# CITY OF ALBUQUERQUE

**Re: 12710 San Jacinto  
12710 San Jacinto Ave. NE  
Request for Certificate of Occupancy  
Transportation Development Final Inspection**  
Architect's Stamp dated 04-19-22 (K22-D063)  
Certification dated 09-18-23

**Re: 12710 San Jacinto**  
**12710 San Jacinto Ave. NE**  
**30-Day Temporary Certificate of Occupancy**  
**Transportation Development Final Inspection**  
Architect's Stamp dated 04-19-22 (K22-D063)  
Certification dated 09-18-23

Date: April 19, 2022  
Sheet: Site Plan

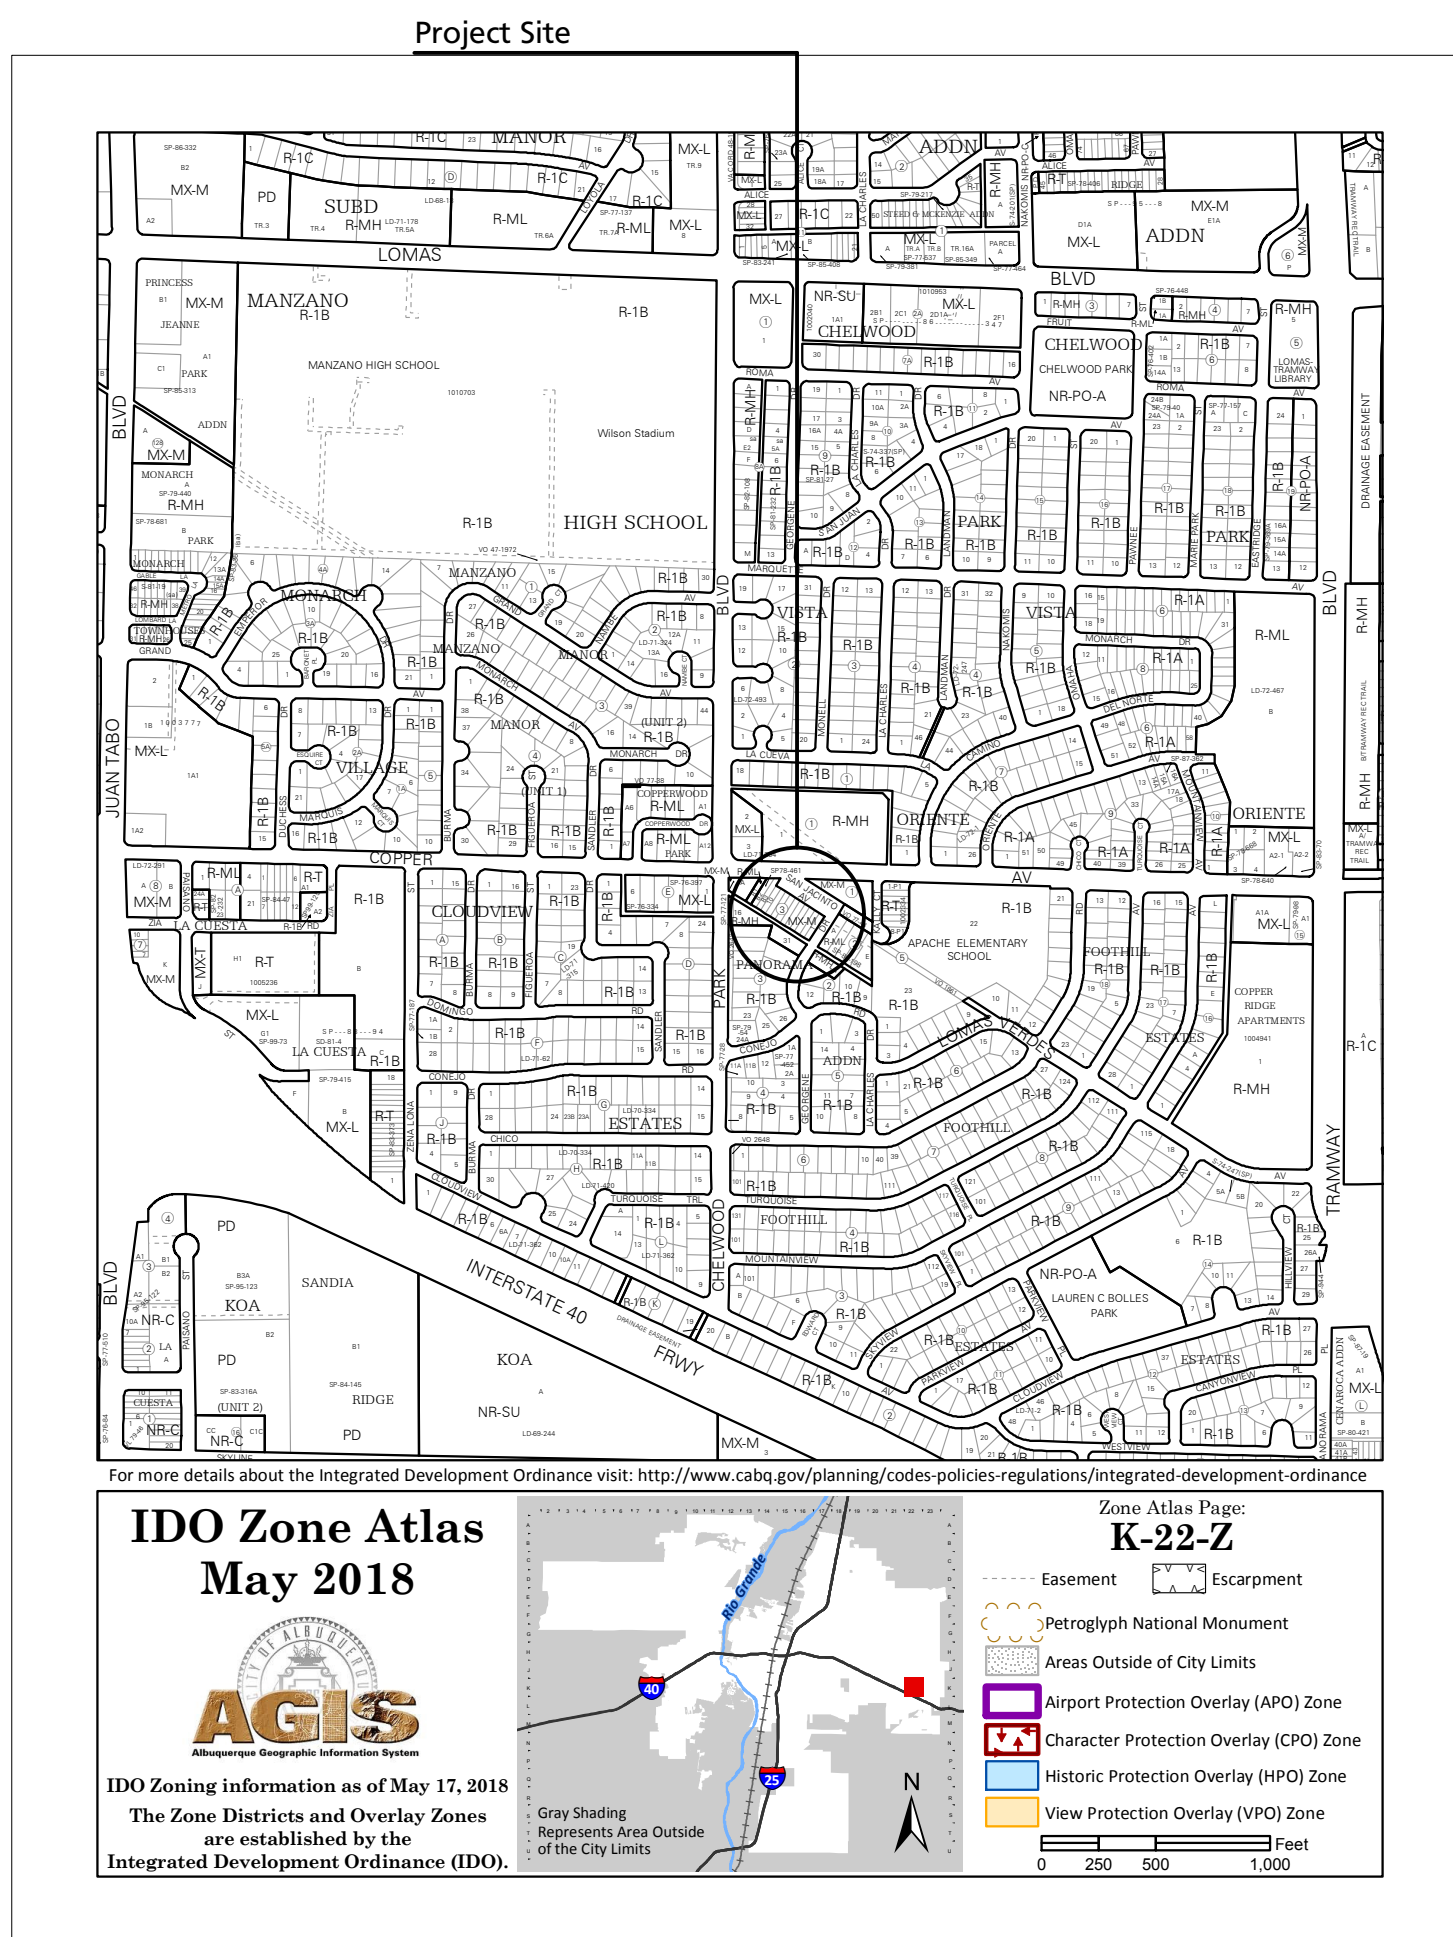
- Per site visit, the cross slope for the pedestrian pathway from the public sidewalk to the building entrance ranges between 2.6-5.9%. The maximum cross slope should be 2%.

- Please anchor down the Bike Rack.
